POST EPC MEMORANDUM

RE: PR-2023-009209 SI-2023-014981- Major Amendment to Site Plan – EPC_6625 Bluewater Rd. NW

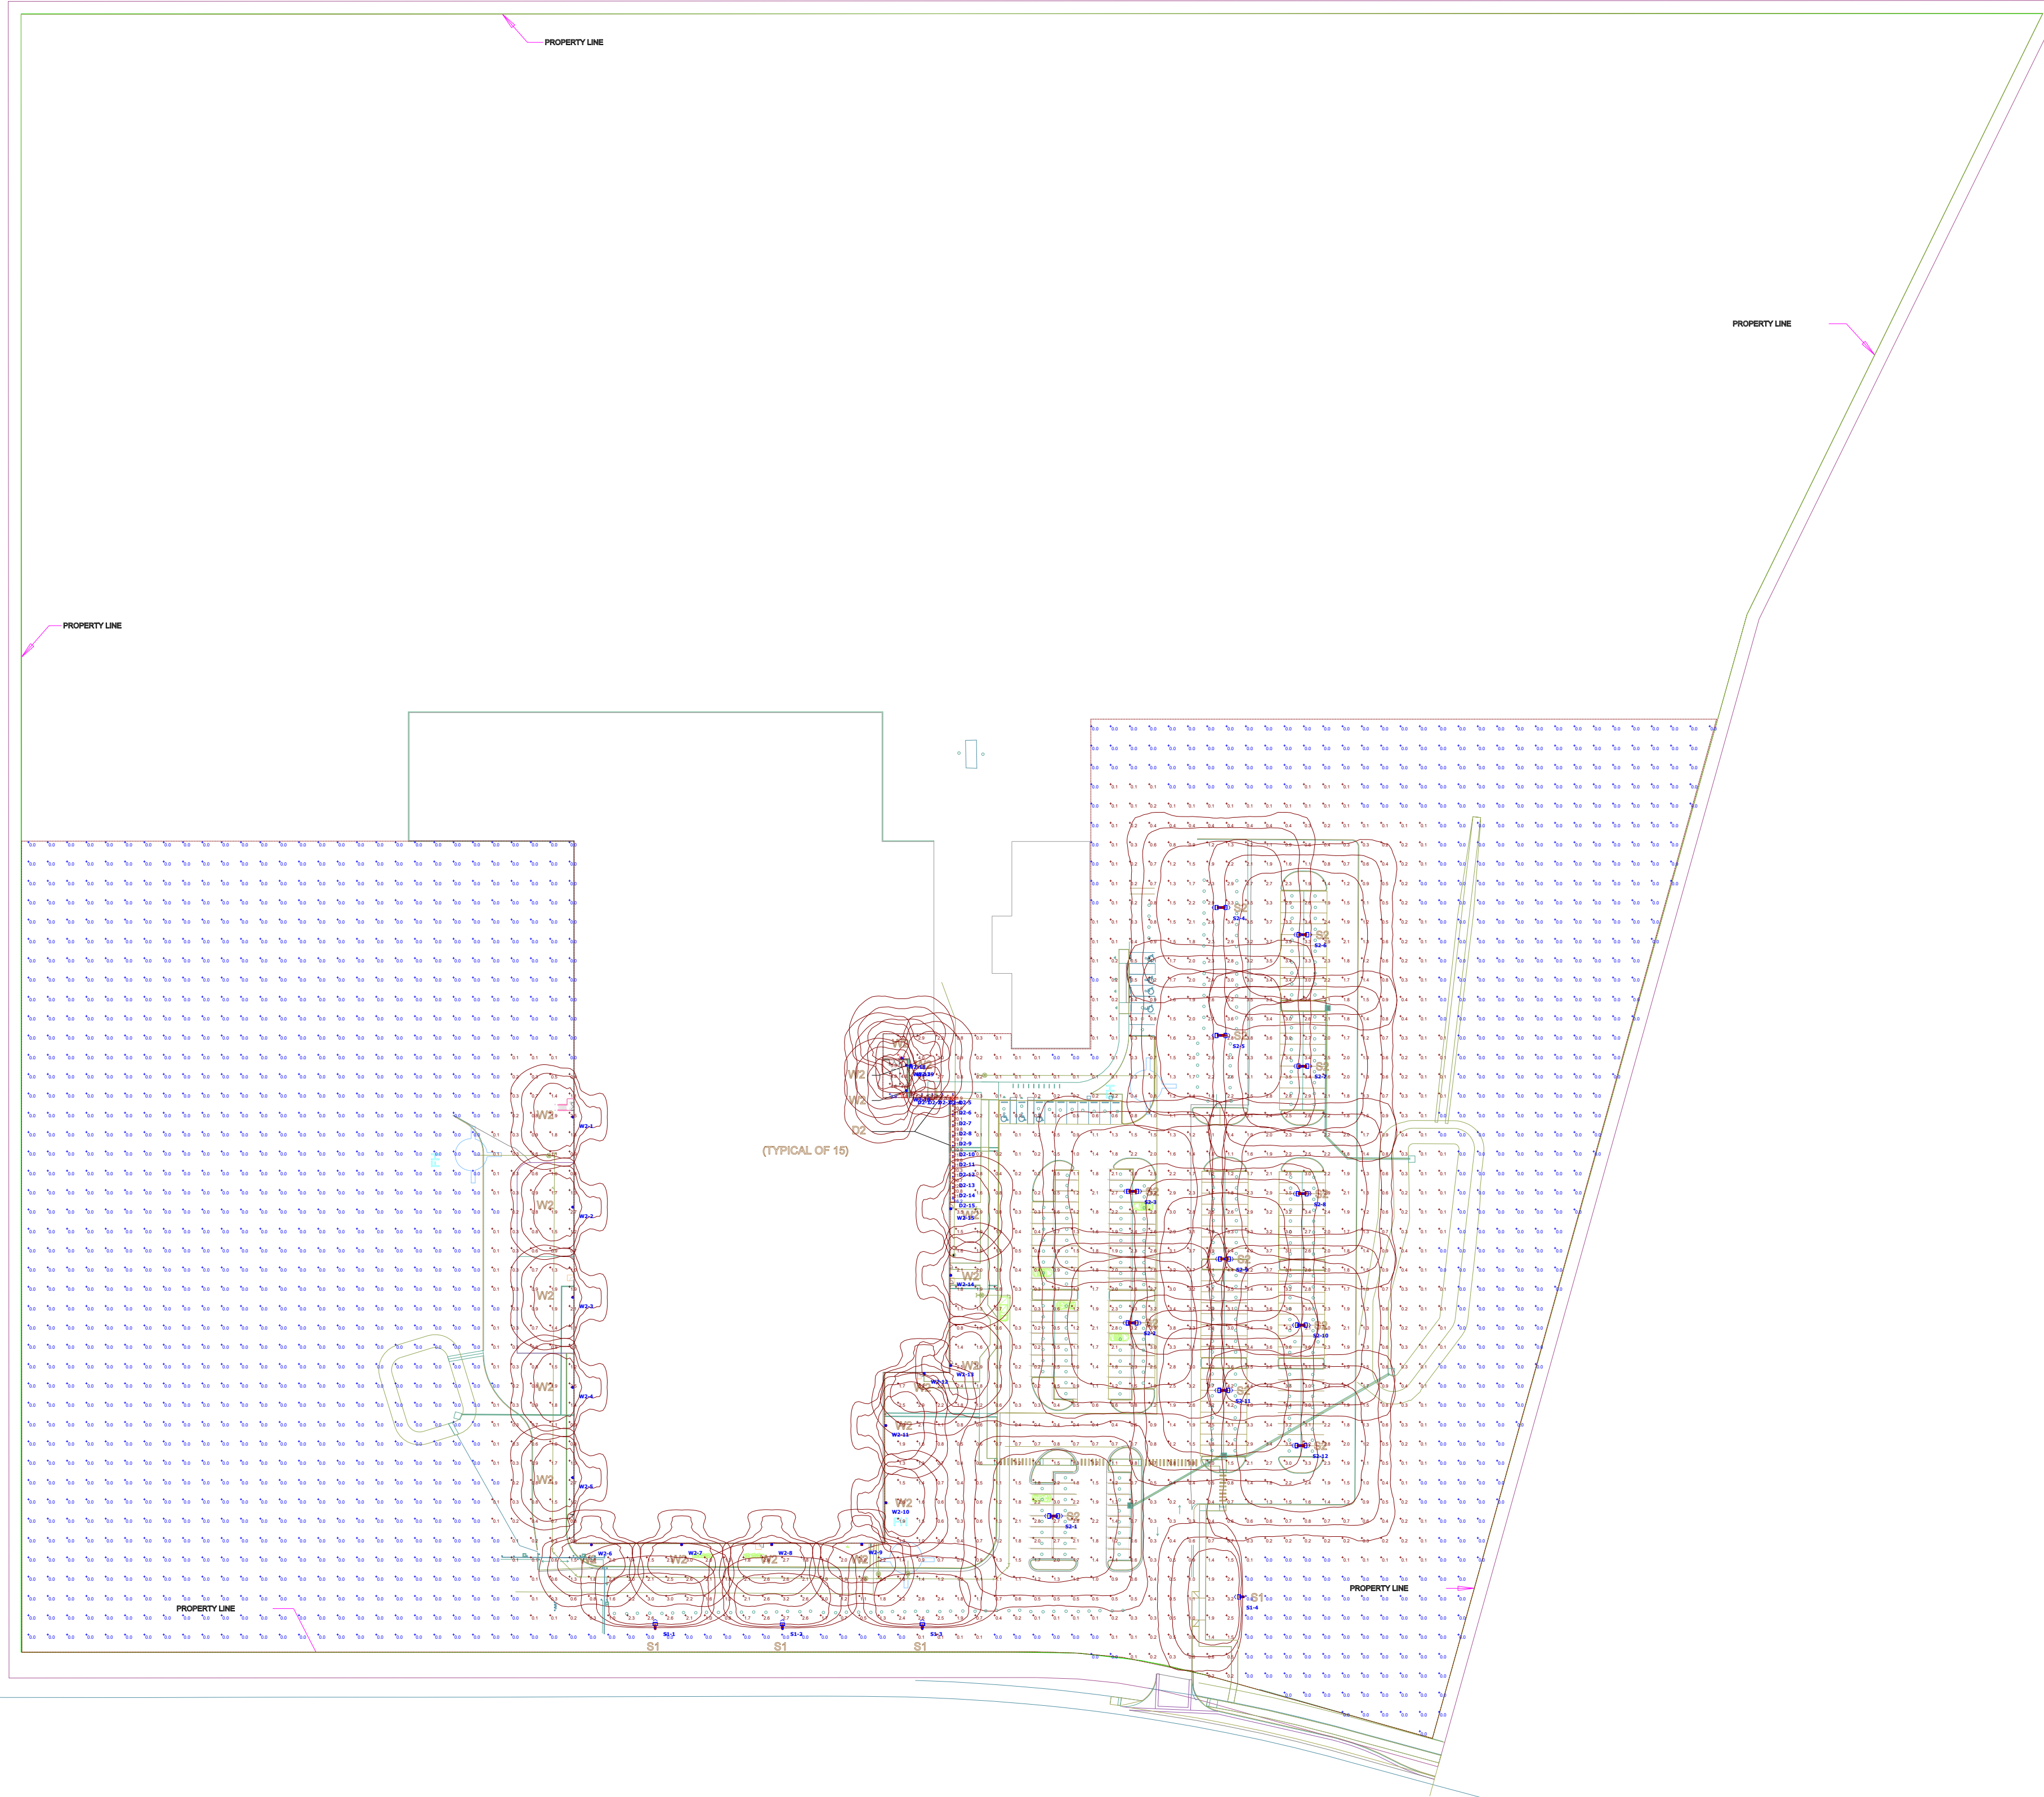
2. Conditions 3 and 4 have been met. Parking lot lighting has been reduced to 18'-6" in height in accordance with CPO-2 regulations regarding Outdoor Lighting.
